APPENDIX B – Response to General Public Submissions

State Significant Development SSDA 8669

St Aloysius' College

MATRIX OF RESIDENT SUBMISSIONS – SSDA 8669																		
ISSUES IDENTIFIED	NUMBER OF TIMES RAISED	COMMENT																
BUILDING BULK AND SCALE																		
- Disappointment the Jeffreys Street Façade is not being upgraded; - Increased height will destroy the view and value of the adjoining properties; - Mass and Density of the development will impact on the adjoining residents and intrude on the skyline; - View impact of the 2.4m acoustic barrier and increase in the parapet height to RL43.49. - Concern over the impact of the new façade element for the entrance raising by 0.67m; - Inadequate setbacks, resultant loss in opportunities to provide meaningful landscaping; - Lack of setback particular acute along 49 Upper Pitt Street and 88 Kirribilli Avenue; - Rectify unsatisfactory and inconsistent material finishes; - There are two Basketball Courts provided on the Junior Campus; - Increase in building height will impact the existing view corridors; - The new north east wing will see an increase in parapet height; - The proposal would be out of proportion with

PROJECT	St Aloysius' College SSDA	PROJECT #	2670
CLIENT	St Aloysius' College	DWG #	DAU125
DWG	Upper Pitt St Plan - LV 1	REVISION	C
CLIENT REF & CONTACT	St Aloysius' College	DATE	Feb 2018
ISSUE	9/4/18	SSDA Submission	
DATE	9/4/18	REVISION

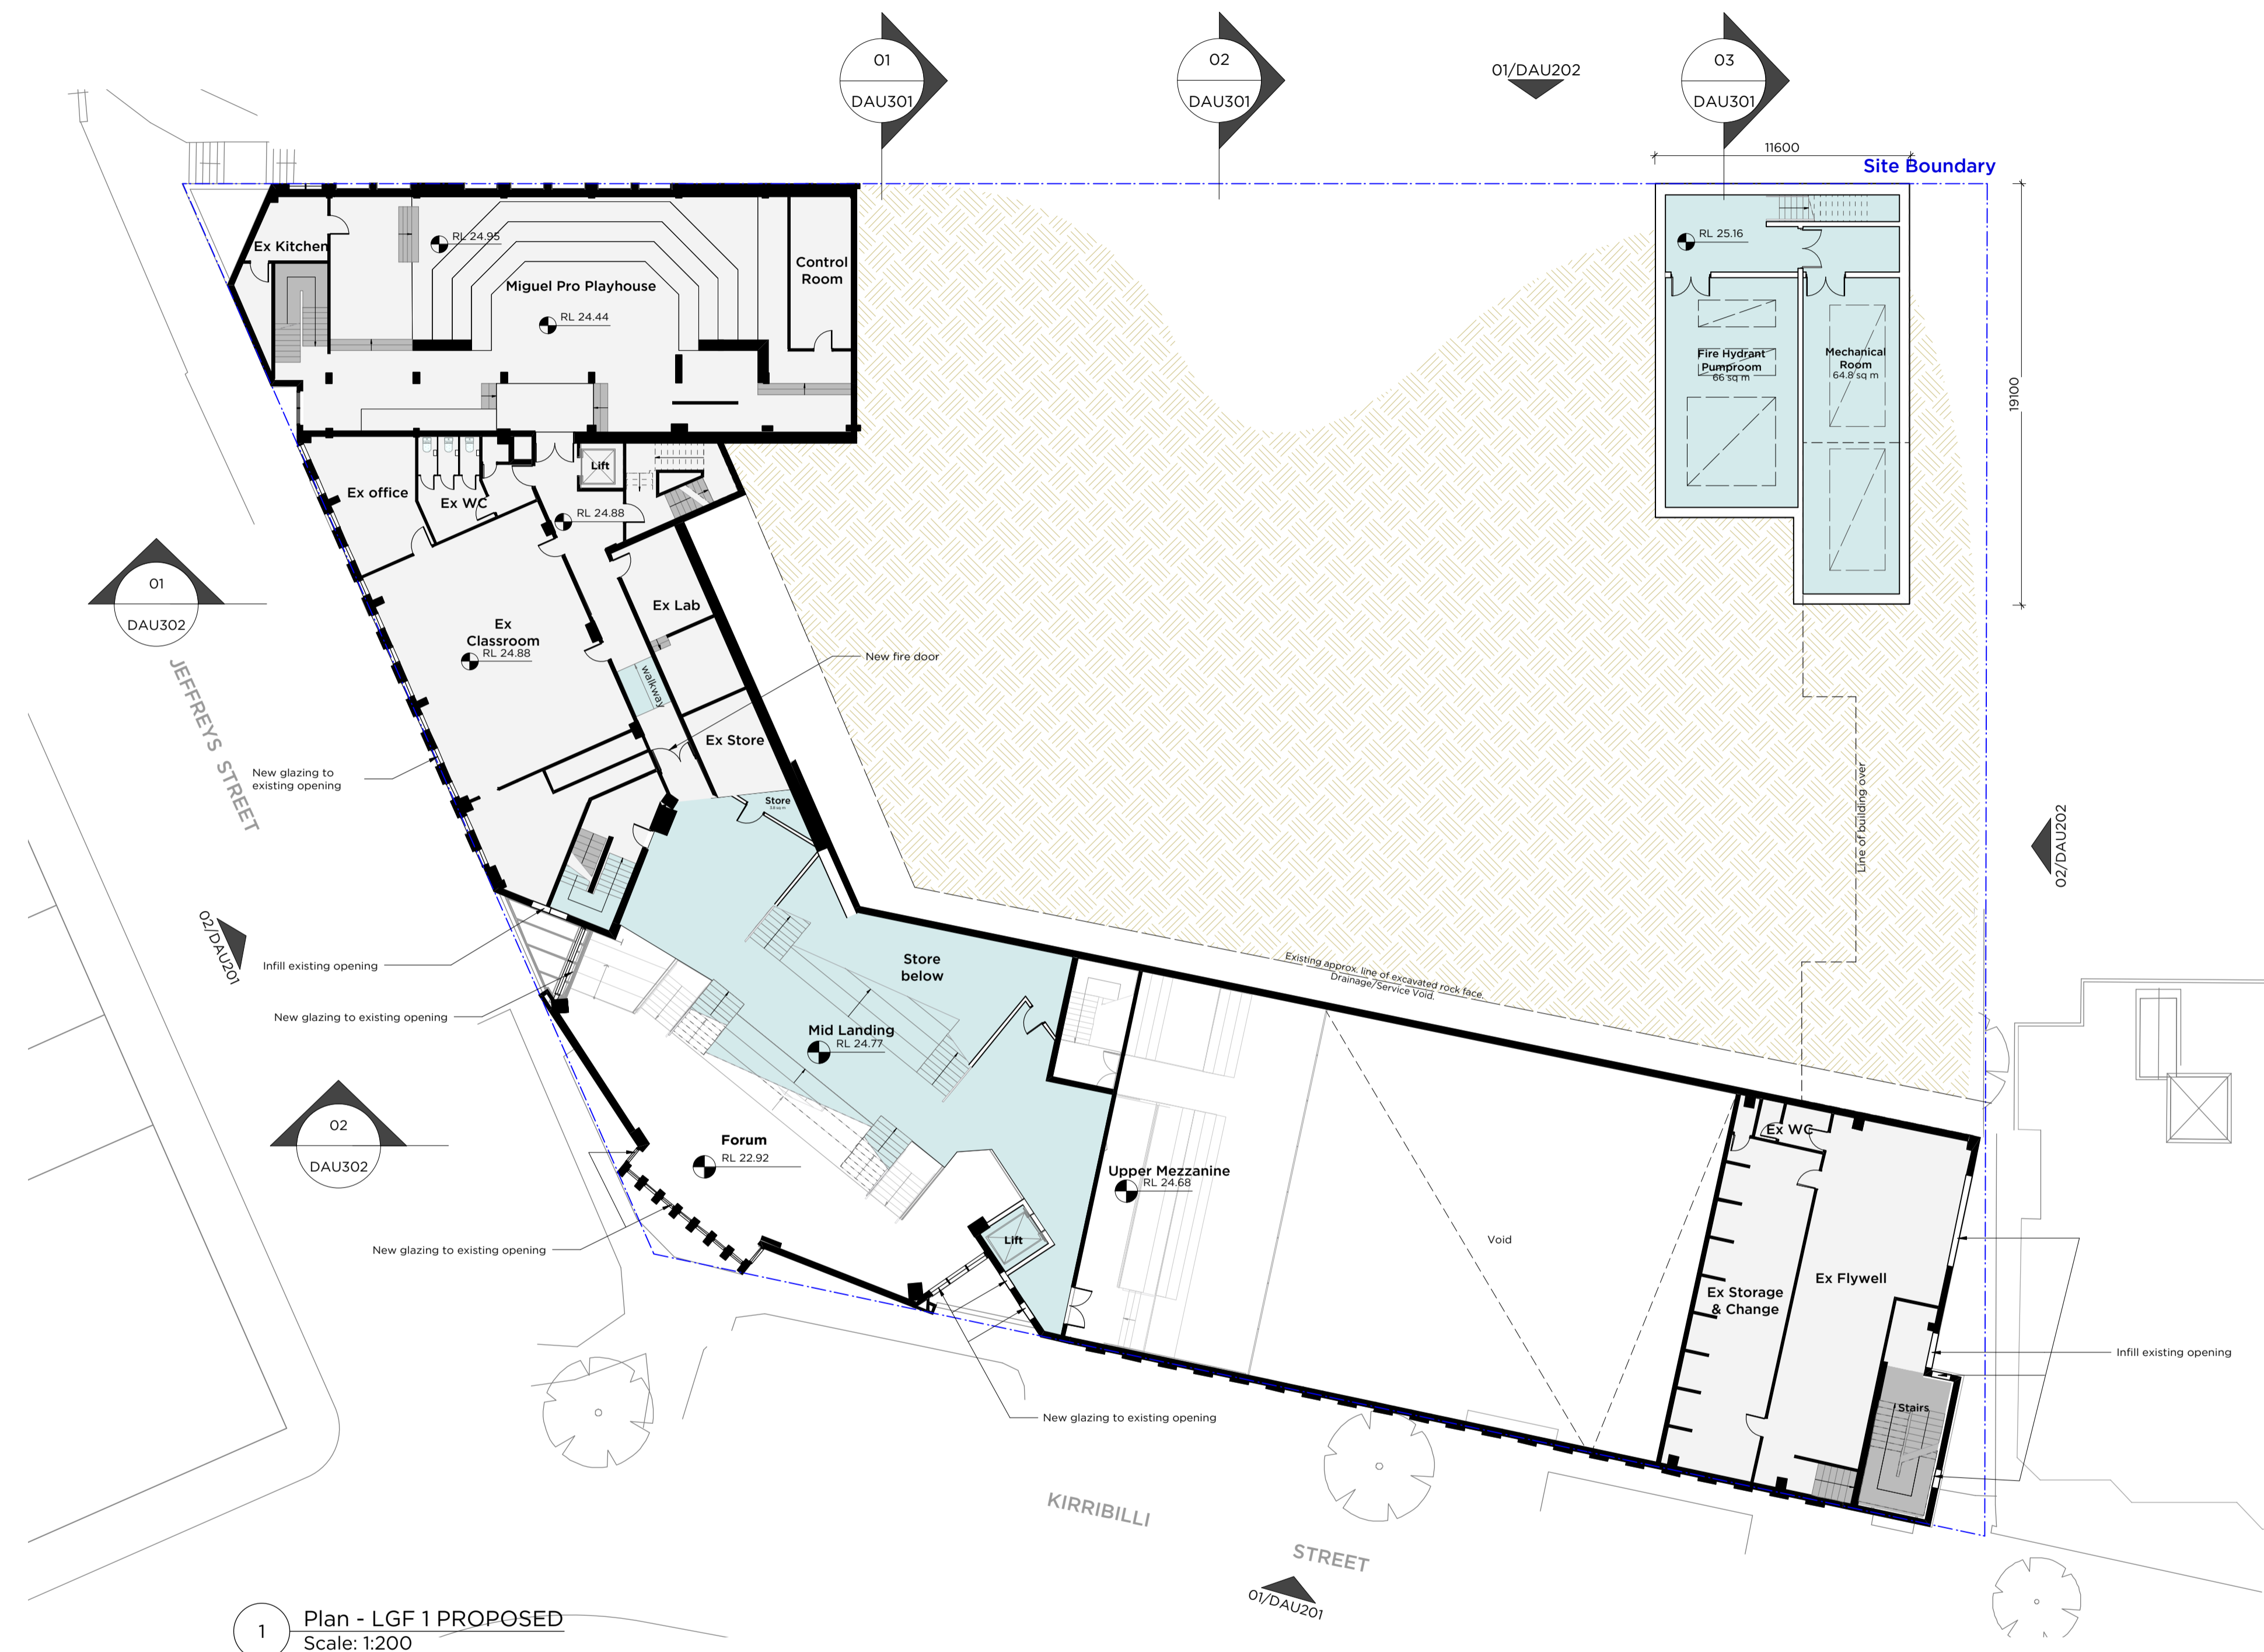
MATRIX OF RESIDENT SUBMISSIONS – SSDA 8669		
ISSUES IDENTIFIED	NUMBER OF TIMES RAISED	COMMENT
		The design for the Main Campus therefore provides for six (6) general learning spaces which serve as home room for each of Years 7-10. These are indicated on drawings DAU125 and DAU126. The six (6) stream structure matches the current enrolment and structure, and is not designed to accommodate additional student enrolments. The spaces provided are appropriate for a typical number of students per call, and are in line with education facility norms. Specialist spaces, including science and art, are in addition to the general learning areas and are provided to meet the curriculum needs of the school in relation to NESA requirements and the academic focus of the College. Therefore, the proposed design addresses the College's brief requirement for contemporary learning environments, and is not based on any future increase in enrolment numbers. Once again there is no intention to increase student numbers under this application.
